Re: Business Addition, 11320 Cochiti SE
Grading and Drainage Plan
Engineer's Stamp dated 12-23-05 (L21-D61)

Re: Traffic Circulation Layout (TCL) Submittal for Building Permit Approval for
Offices and Warehouse for Lot 6A Block 9 [L-21/D-61]
(11320 Cochiti Rd. SE), Albuquerque, NM
Engineer's/Architect's Stamp Dated 02-27-06

**Re: East Central Business Addition, 11320 Cochiti Rd. SE, (Lots 7& 8),
Traffic Circulation Layout, Engineer's Stamp dated 12-25-05 (L21-D61)**

DESIGNED BY:	DRAWN BY: T.D.S.	CHECKED BY:	REVISION	BY	DATE	MARK
<p>11320 COCHITI RD. S.E.</p> <p>PROPOSED SITE PLAN</p> <p>GRADING AND DRAINAGE PLAN</p>						
DRAWING NUMBER						
C1						
2 OF 2

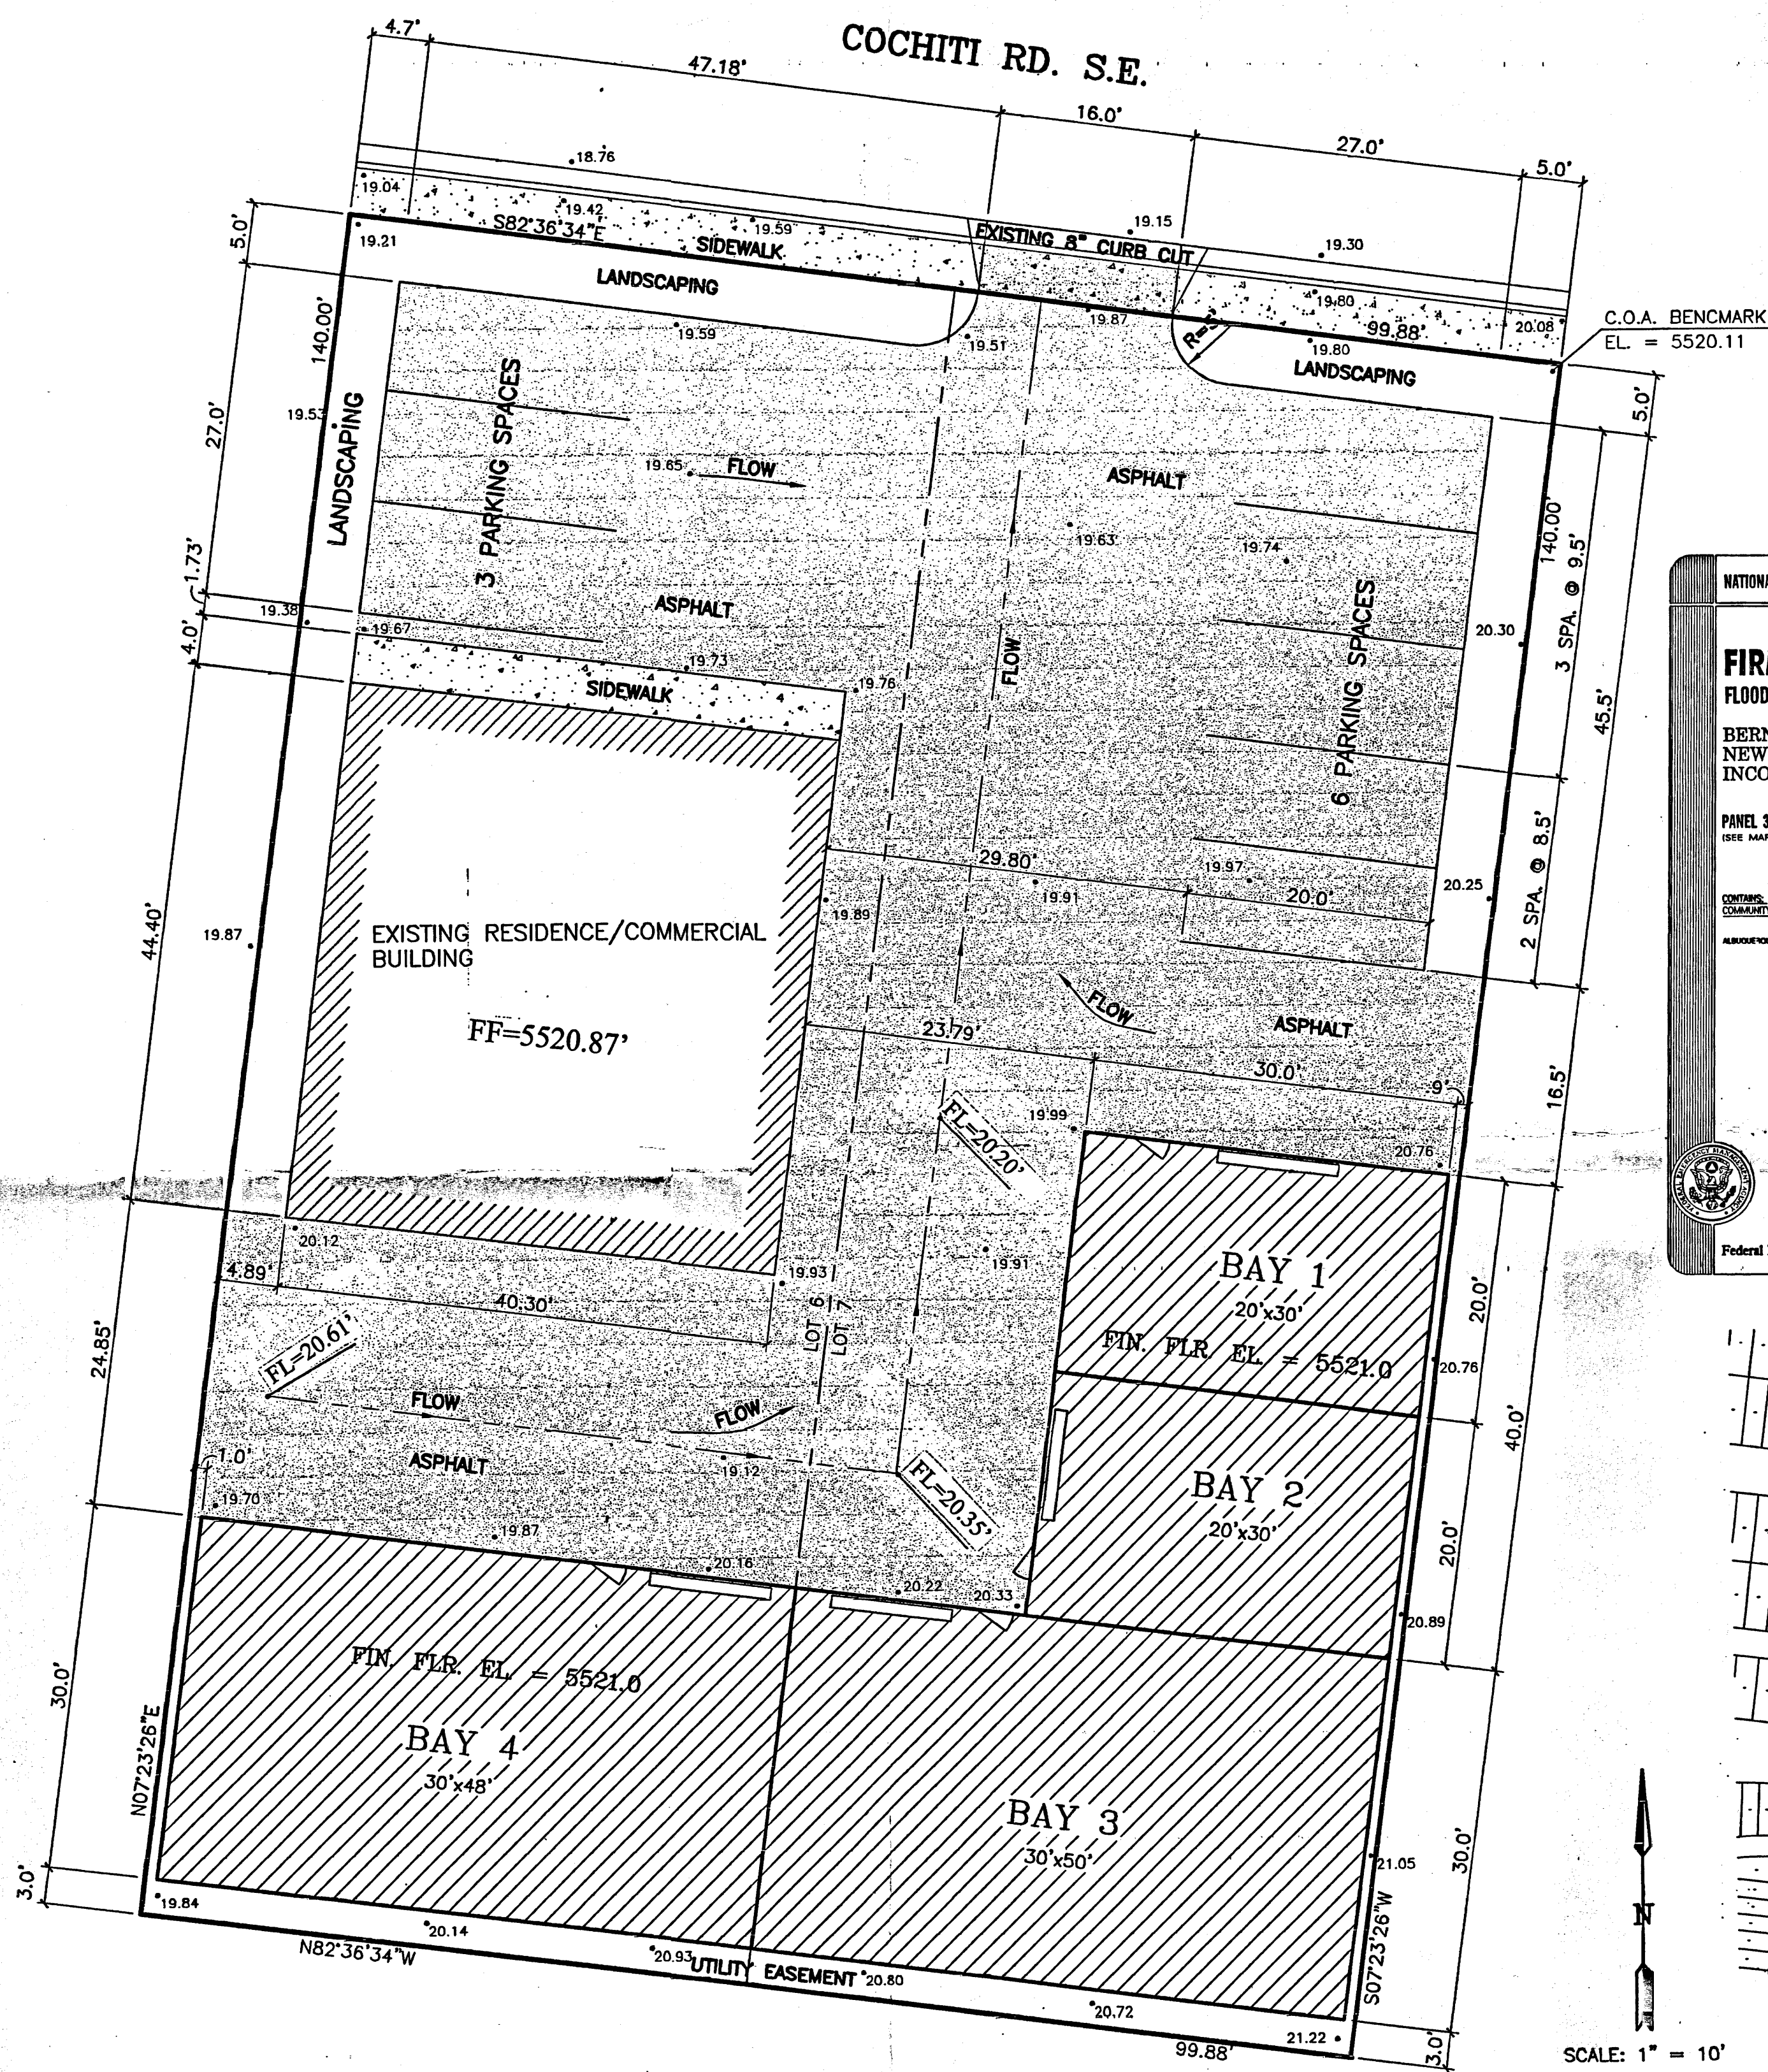
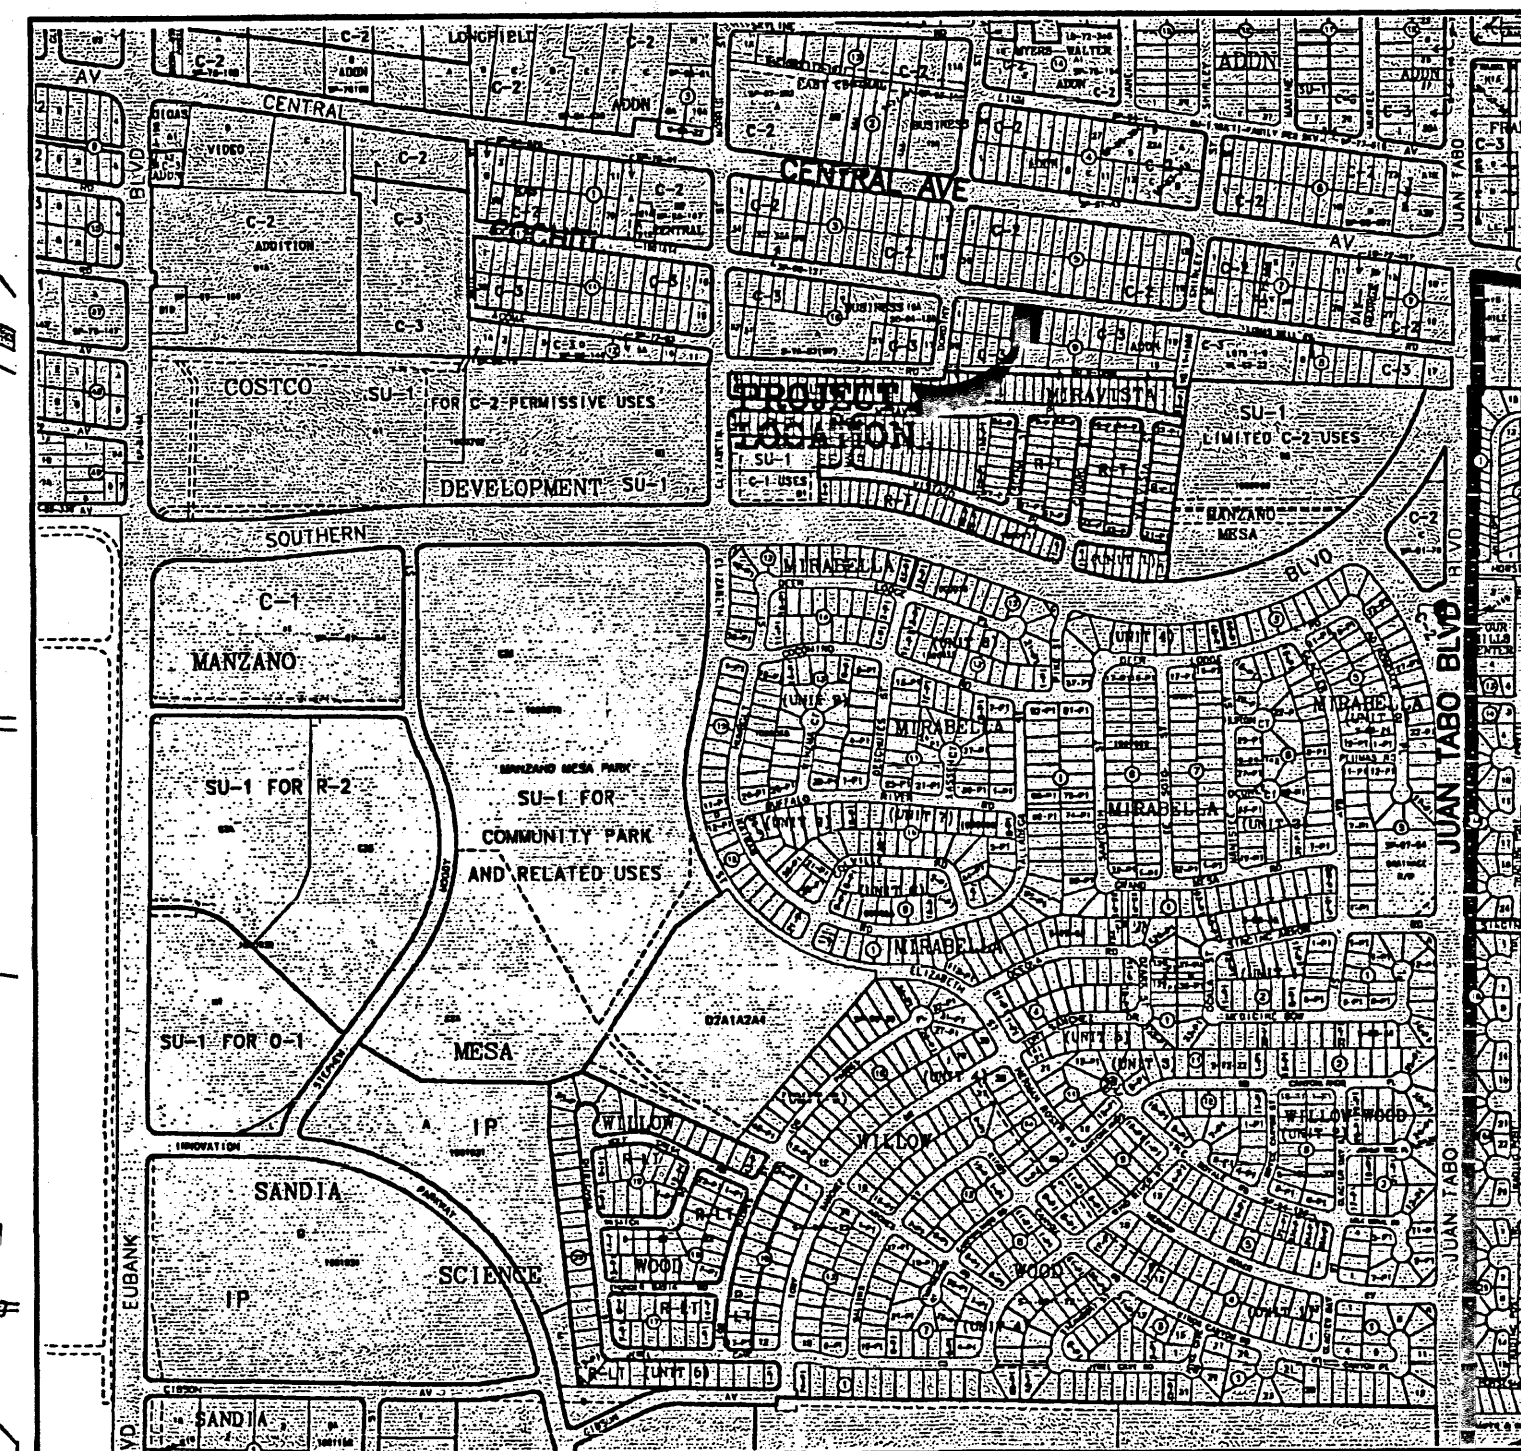
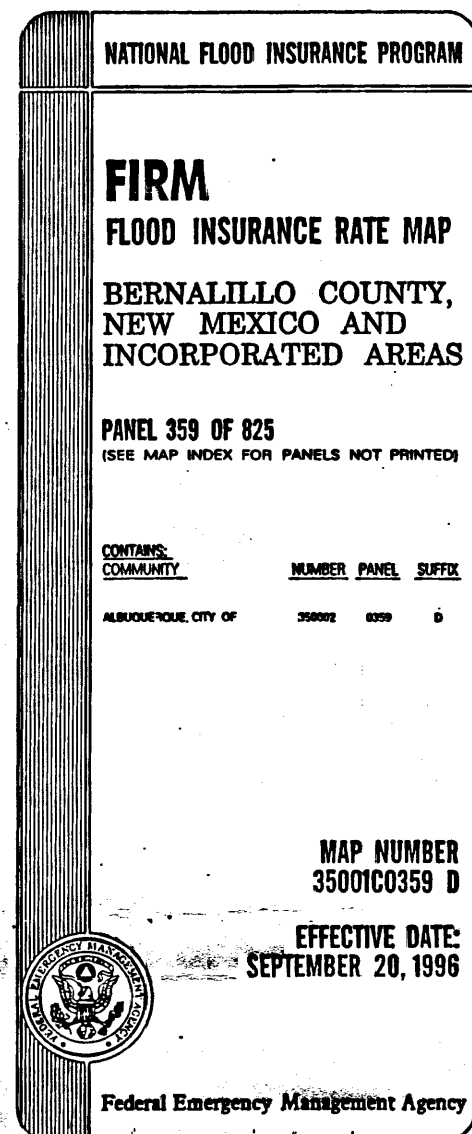
Contractor will need
to ~~install~~ gutters
so water will flow
into parking lot &
into Cochiti.

unless Eng.
certifies that Roof
Drain Gutters have
been installed & is
draining to Cochiti
